Gatwick Northern Runway

TR020005

National Highways Comments on Responses to Examining Authorities Written Questions

May 2024

Permanent Diversion of 346_2Sy

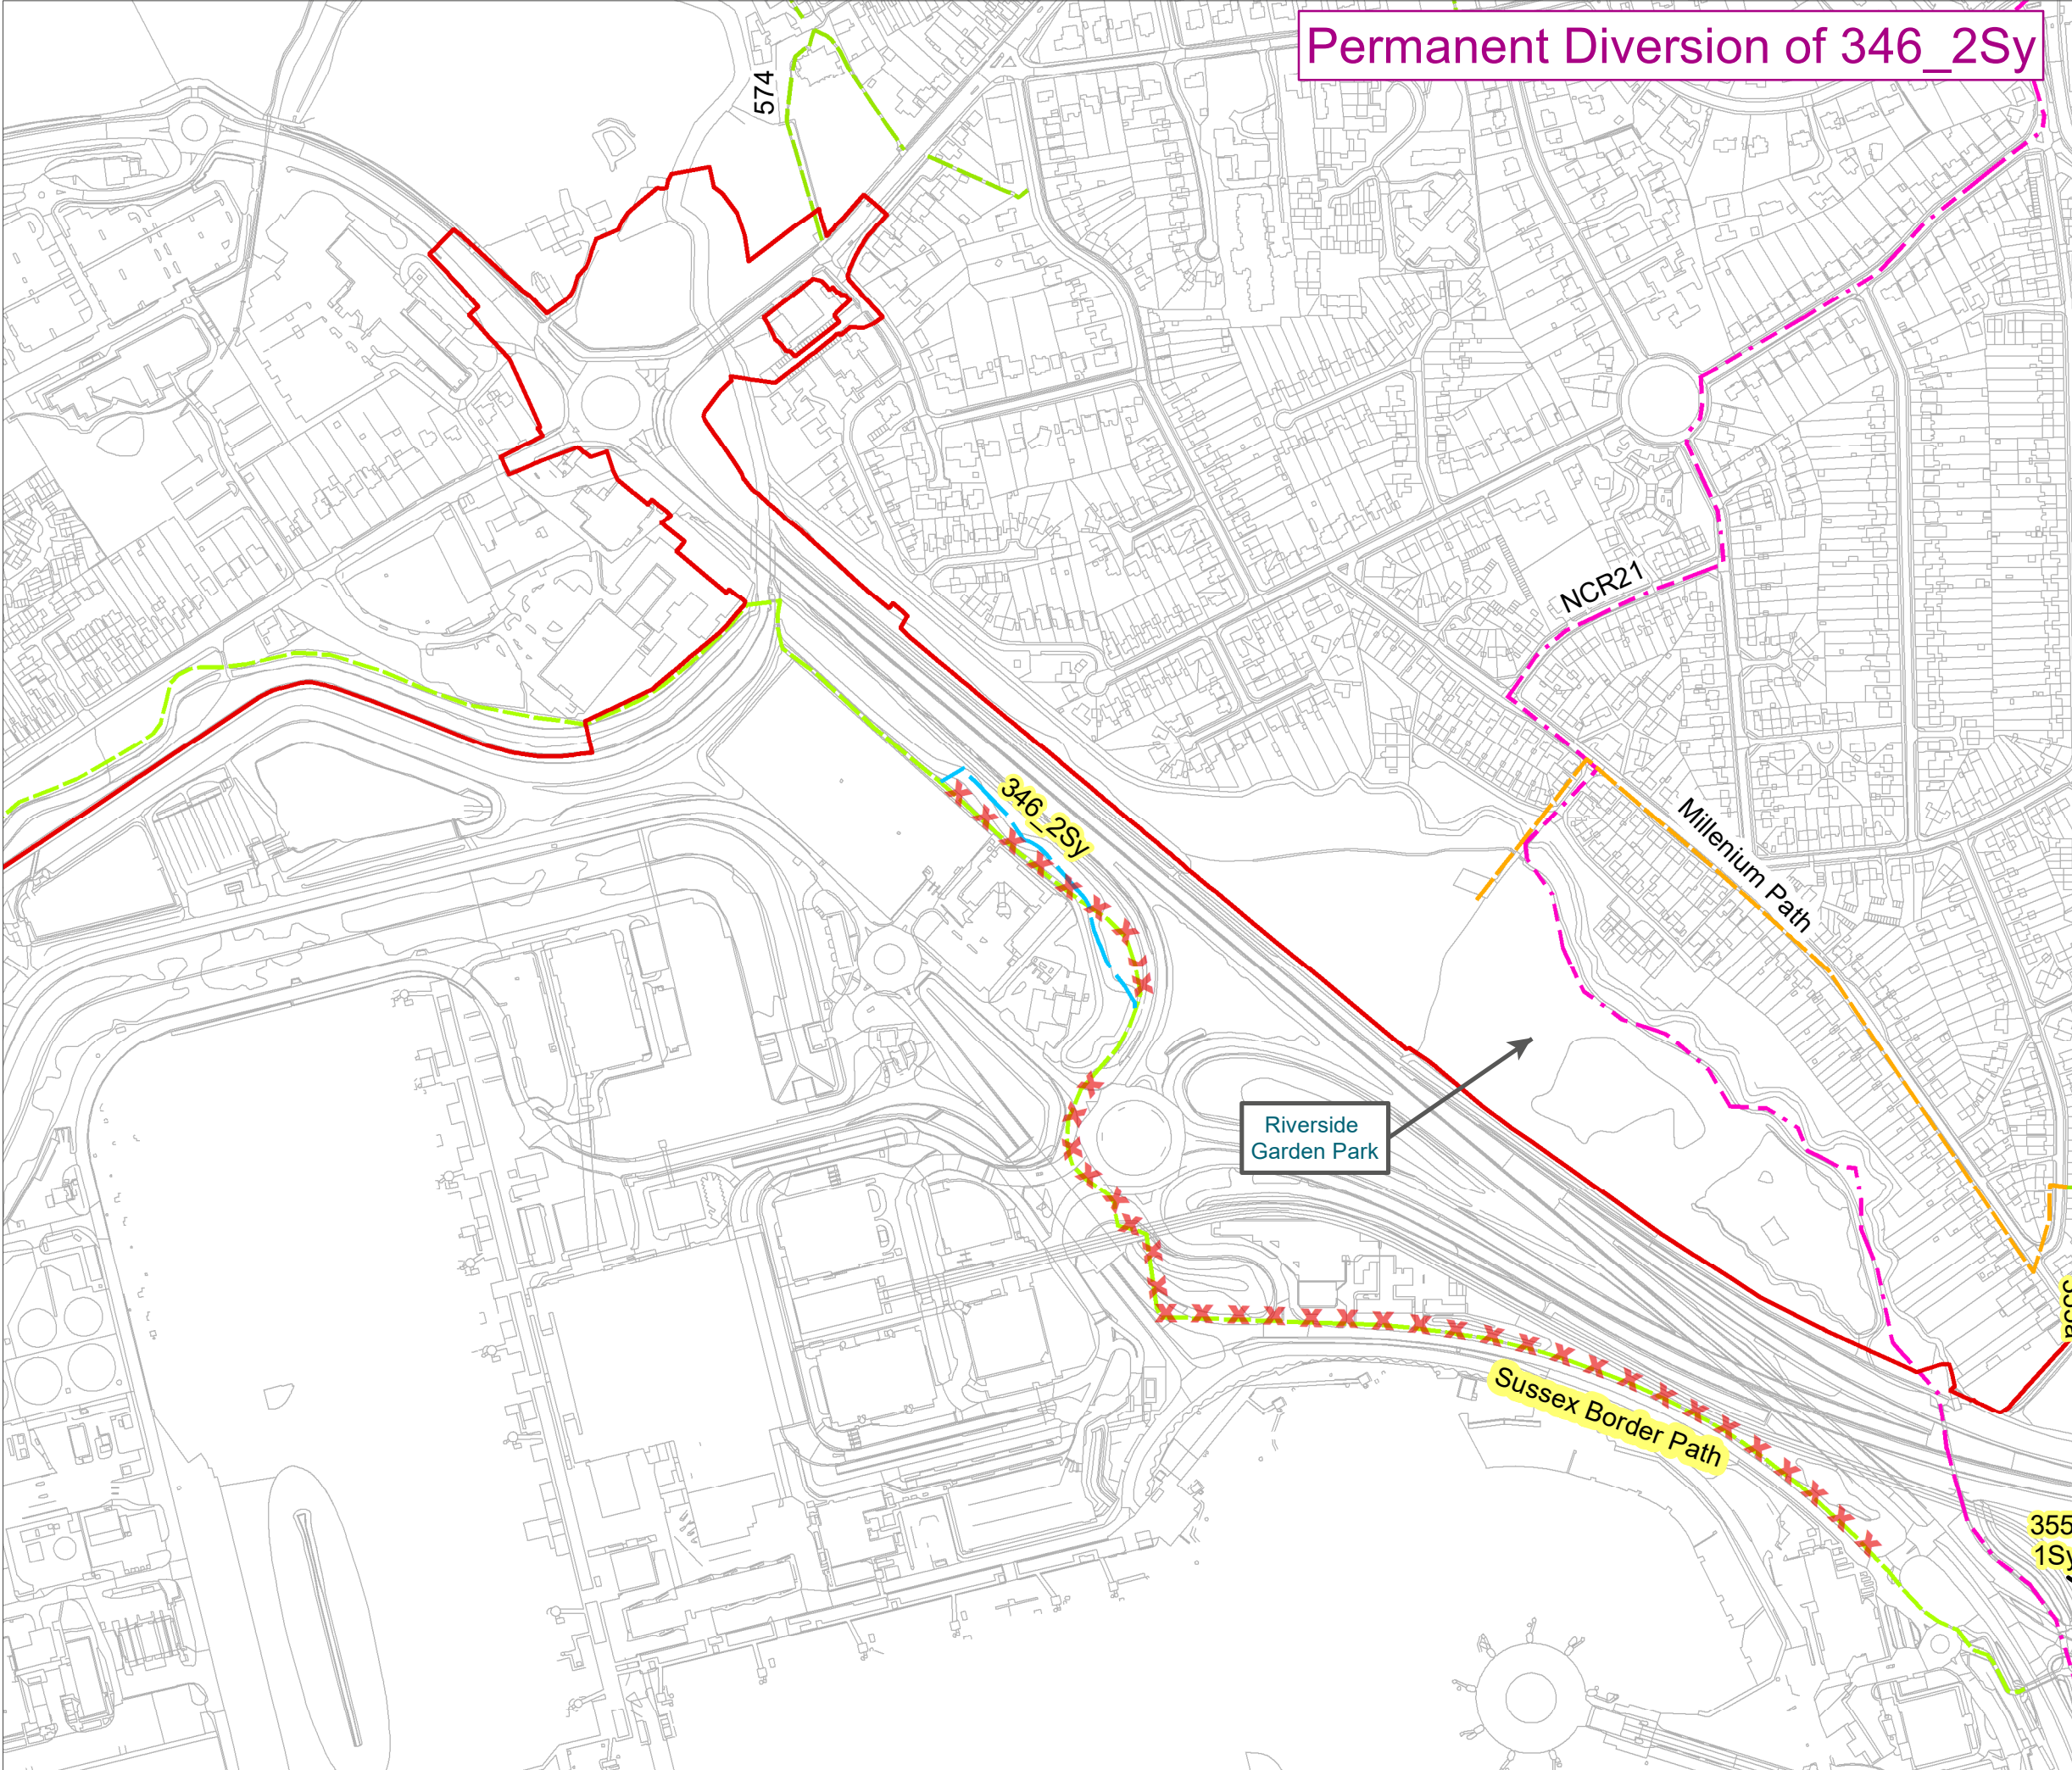
WQ No	Question to / Response by	Question Posed	Response Provided	National Highways Comments
			<p>a PRoW could not be diverted onto a highway and an alternative publicly accessible route would be provided.</p> <p>However, it is the Highway Authority's understanding that these routes are not to be publicly adopted highway but will sit within GAL's control. Therefore, the proposed extinguishment is removing the public right of access without providing an alternative public right of way. The Applicant therefore has three potential options to ensure this newly proposed route [Reference C2 to C8 shown in pink on Rights of Way & Access Plans [APP-018]] has suitable public access rights, they are:</p> <ul style="list-style-type: none"> • Proposed full bridleway status of the route and ensure it is suitably designed to cater for all potential users • Propose footpath status, but alternative provision for cyclists would need to be considered • Footpath but with permissive cycle route
